Application no: H08-0632-11

Description: Proposed two-storey side extension

Location: 55 Clough Road
Gosberton Risegate
Spalding
Lincs
PE11 4JW
PE11 4JW

Amendment: Re-position extension closer to rear elevation and lower ridge height (dwg. no. WEN/1443/11/01)

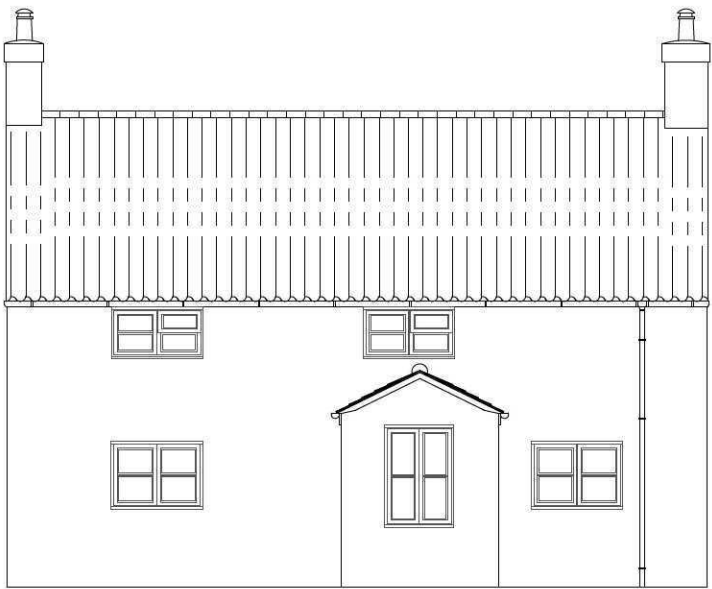
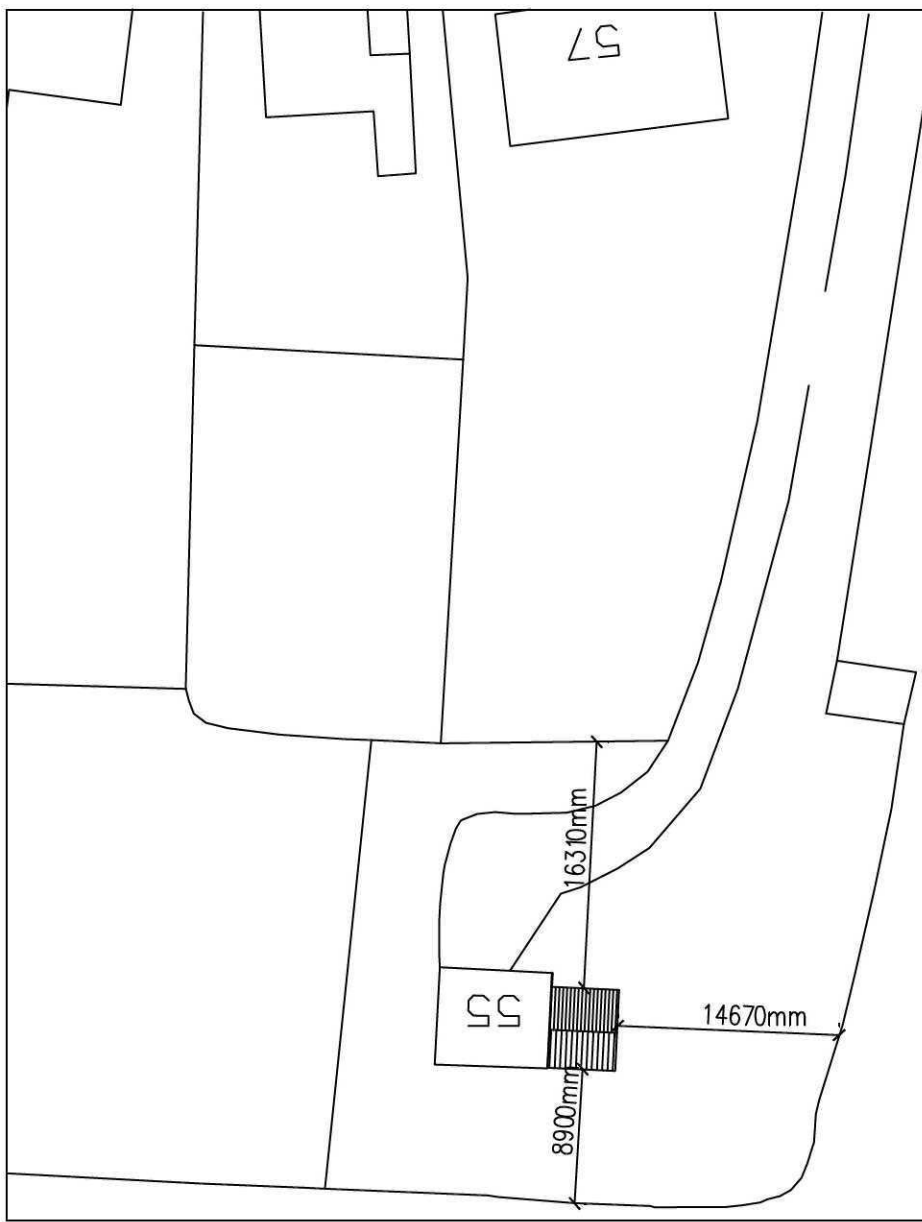
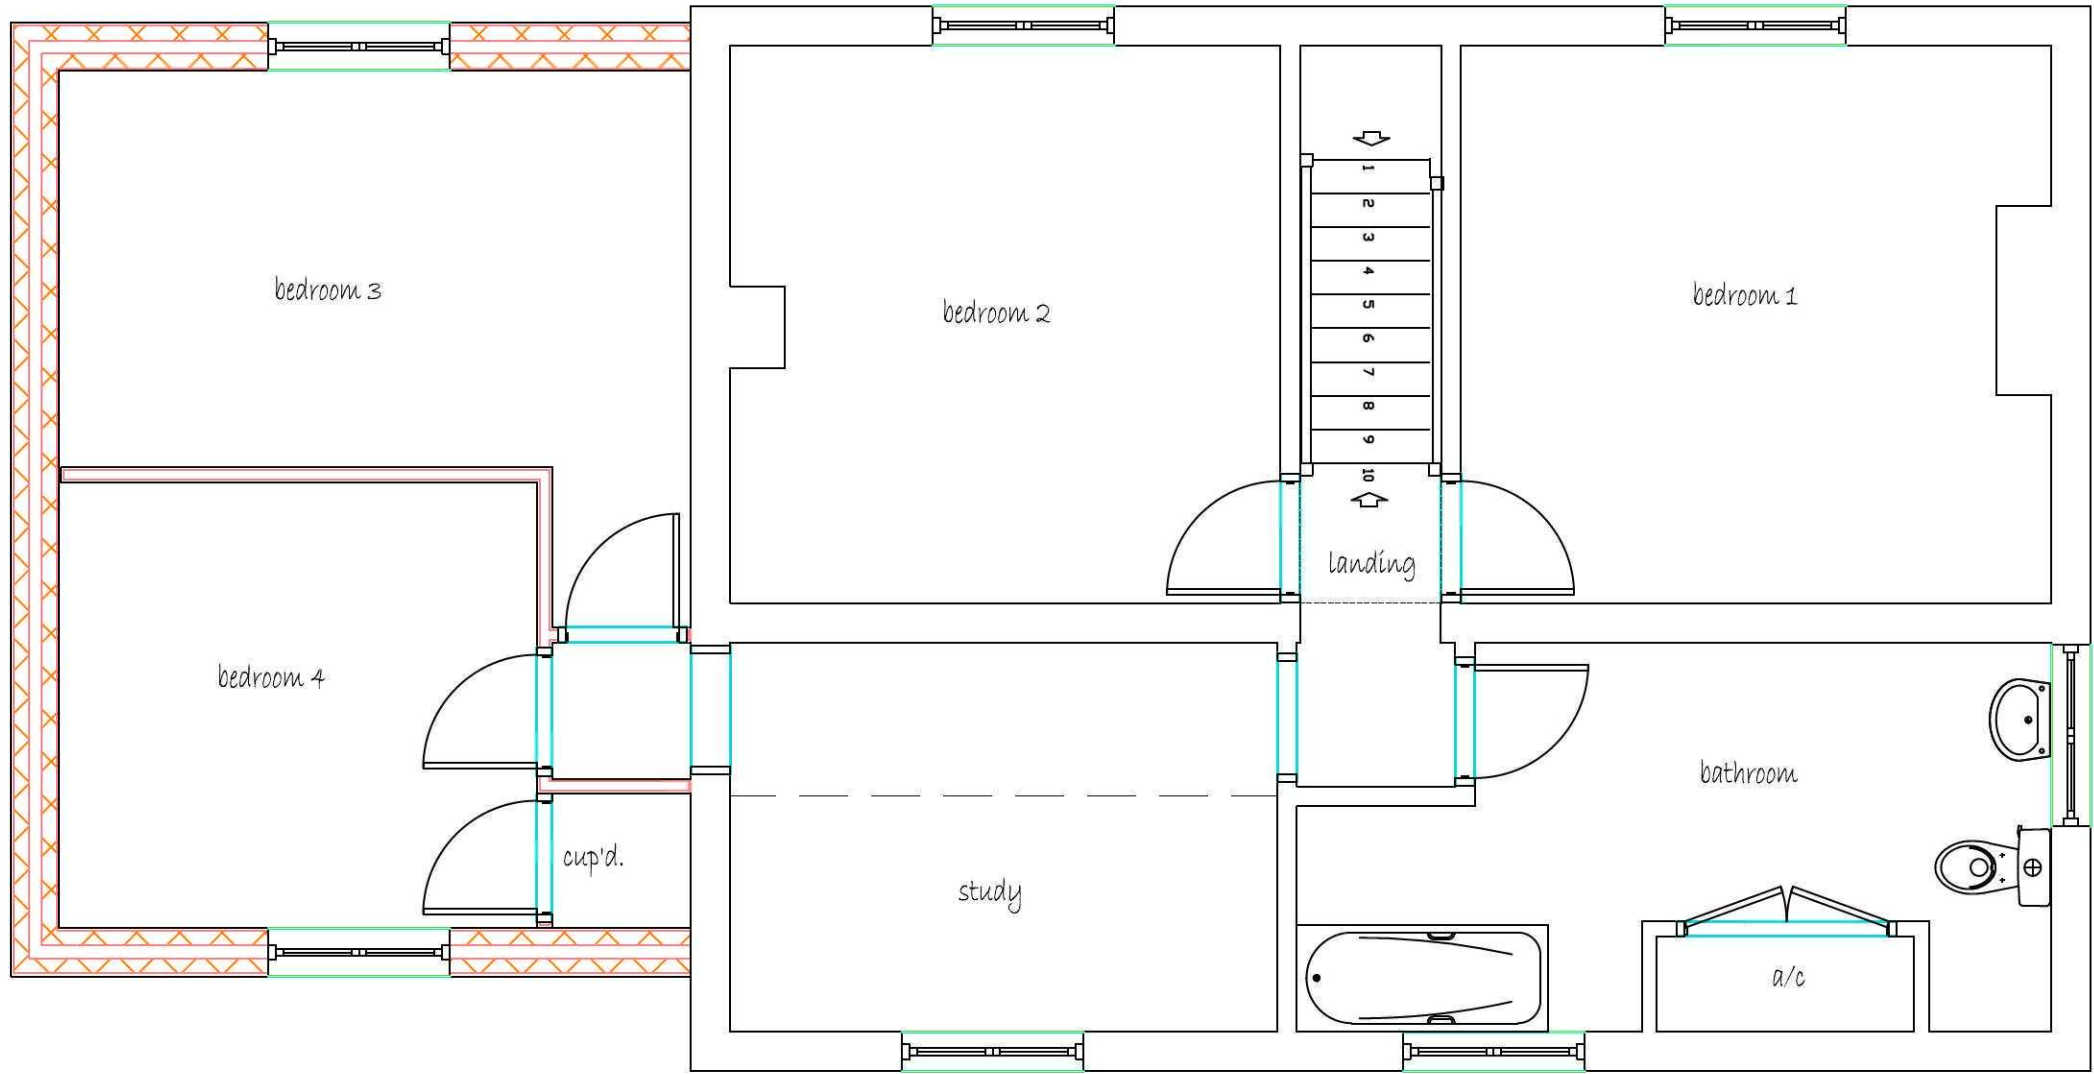
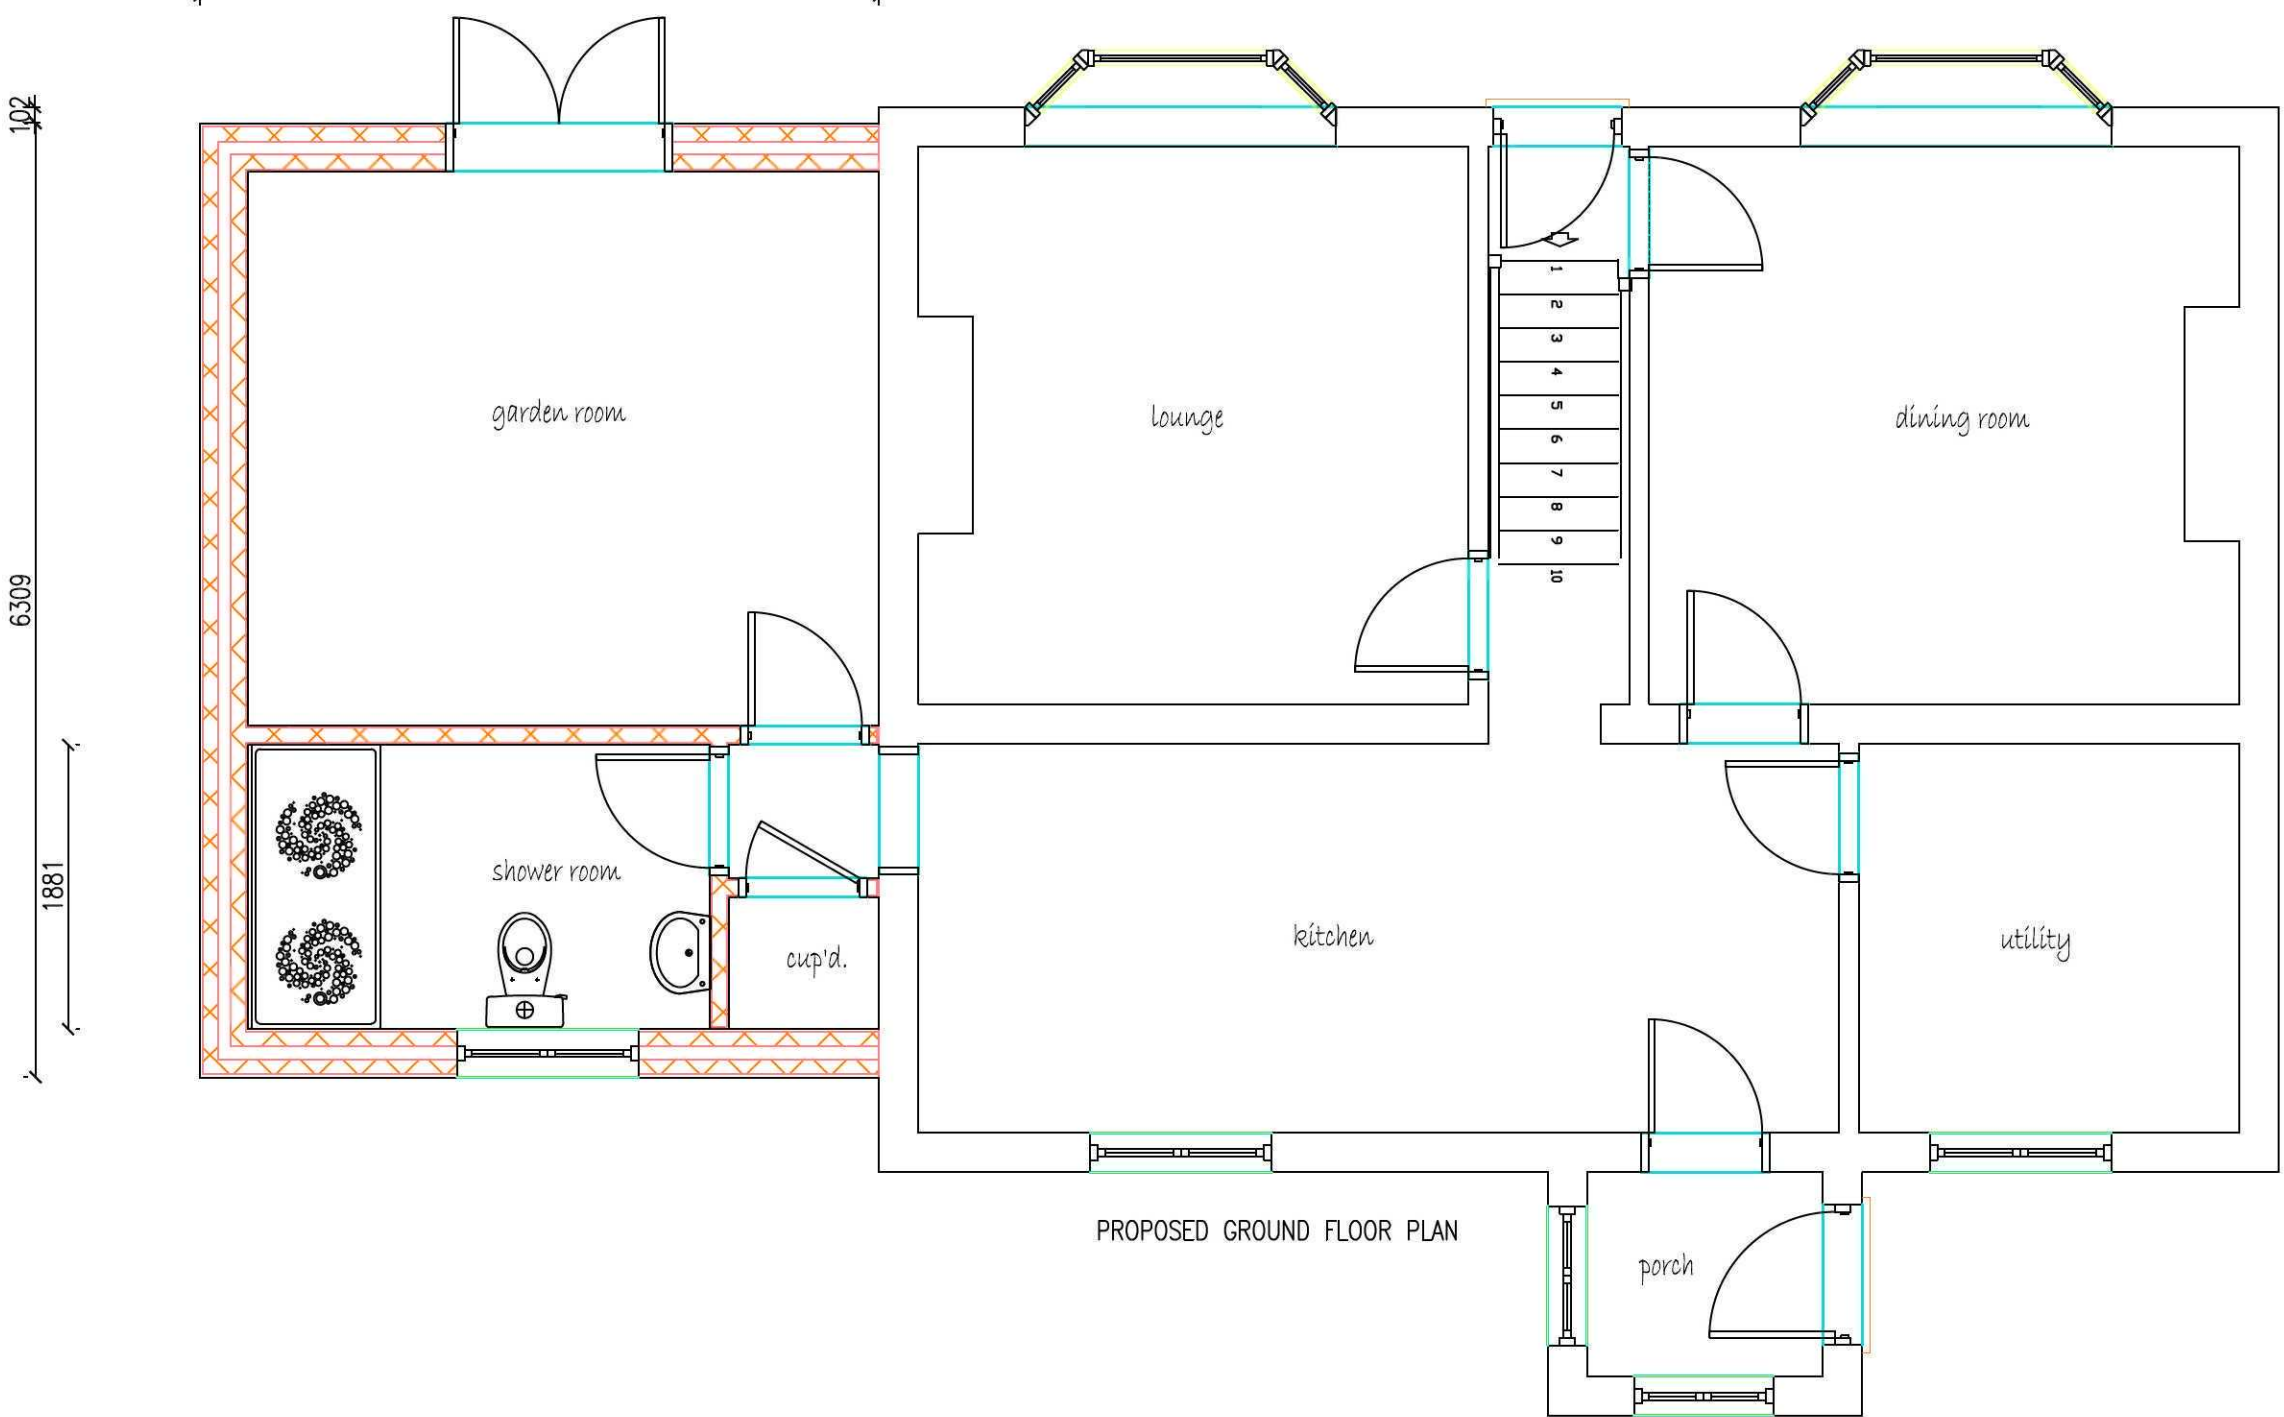
The amendment is re-position the extension closer to the rear elevation and lowering the ridge height.
